**Howerton Services, PLLC**  
**License # P-1716**  
3513 Cathedral Bell Road  
Raleigh, NC 27614  
(919) 270-3460

May 2, 2024

Subject: 404 Ponchartrain Street  
Fuquay Varina, NC 27526  
Plan Revision Letter  
Harnett County Permit #: SFD2106-0010

**S1**  
**01** FOUNDATION PLAN  
1/4" = 1'-0"

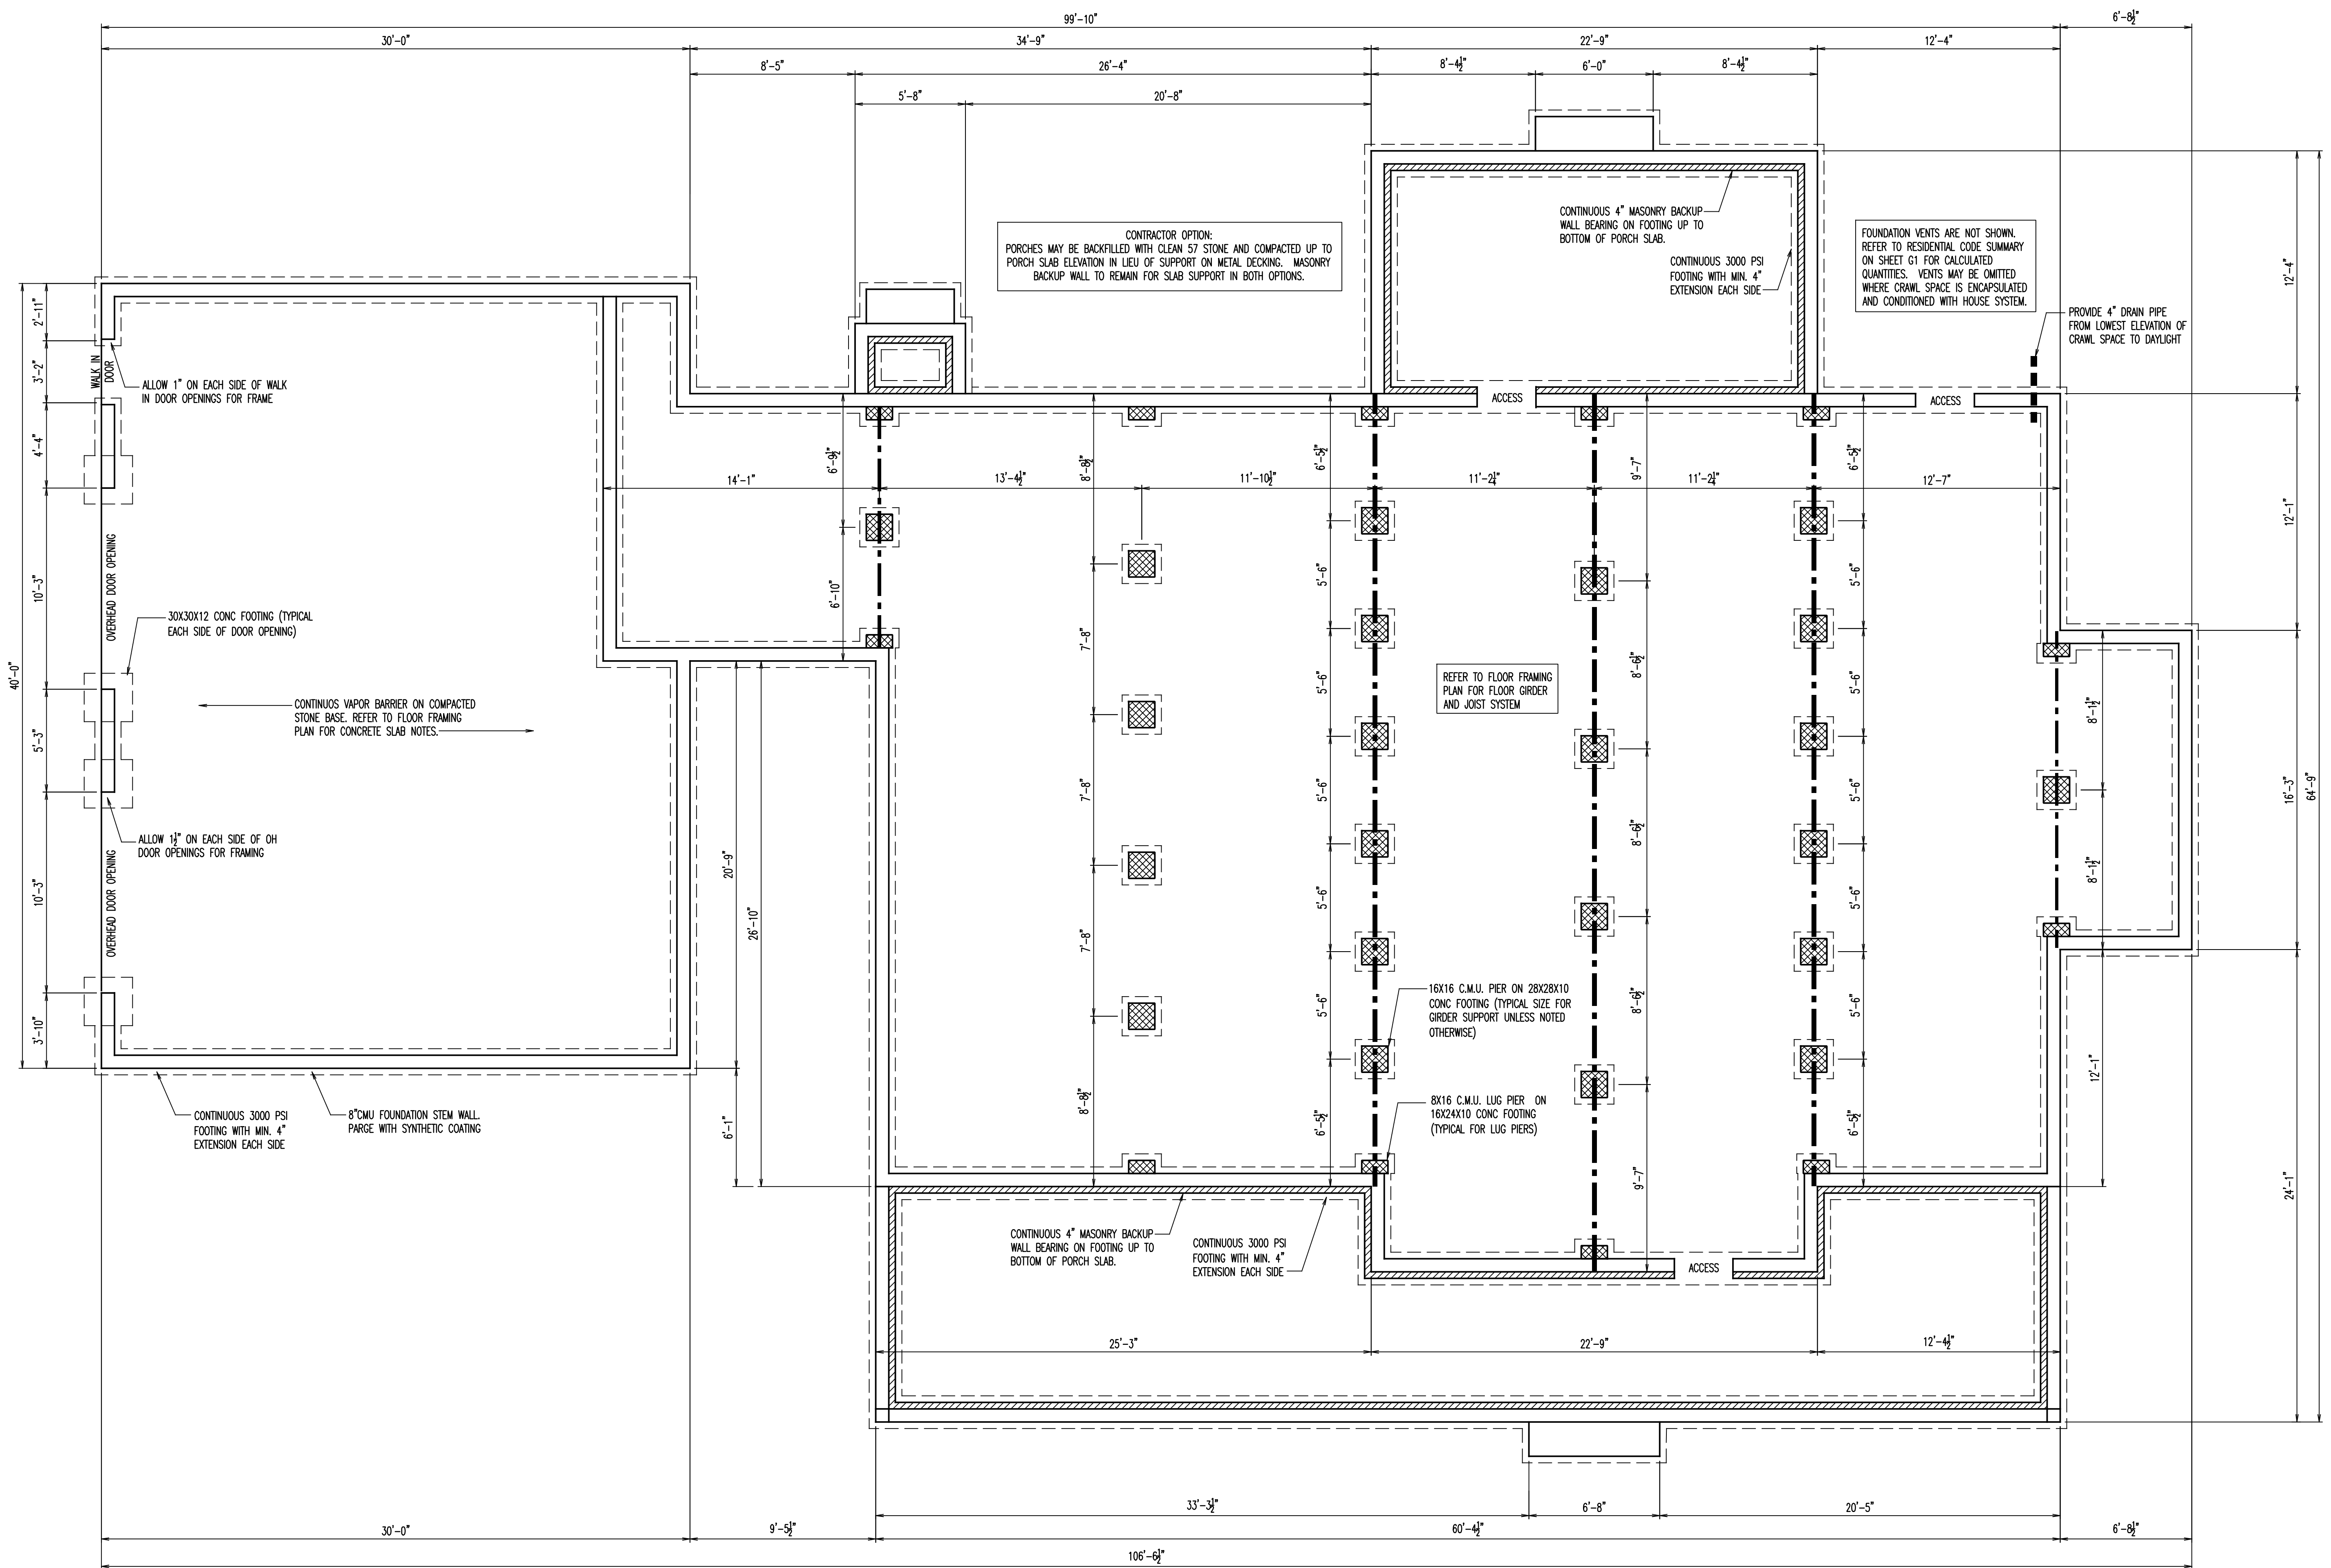
- Item 1 – The continuous footings for this project will be modified. The new continuous footings will be 19”x 8”. All other footings shown in the plans will remain the same. The revised footings are acceptable.

The footing revision noted above meets all the requirements of the 2018 North Carolina Building Code for Residences.
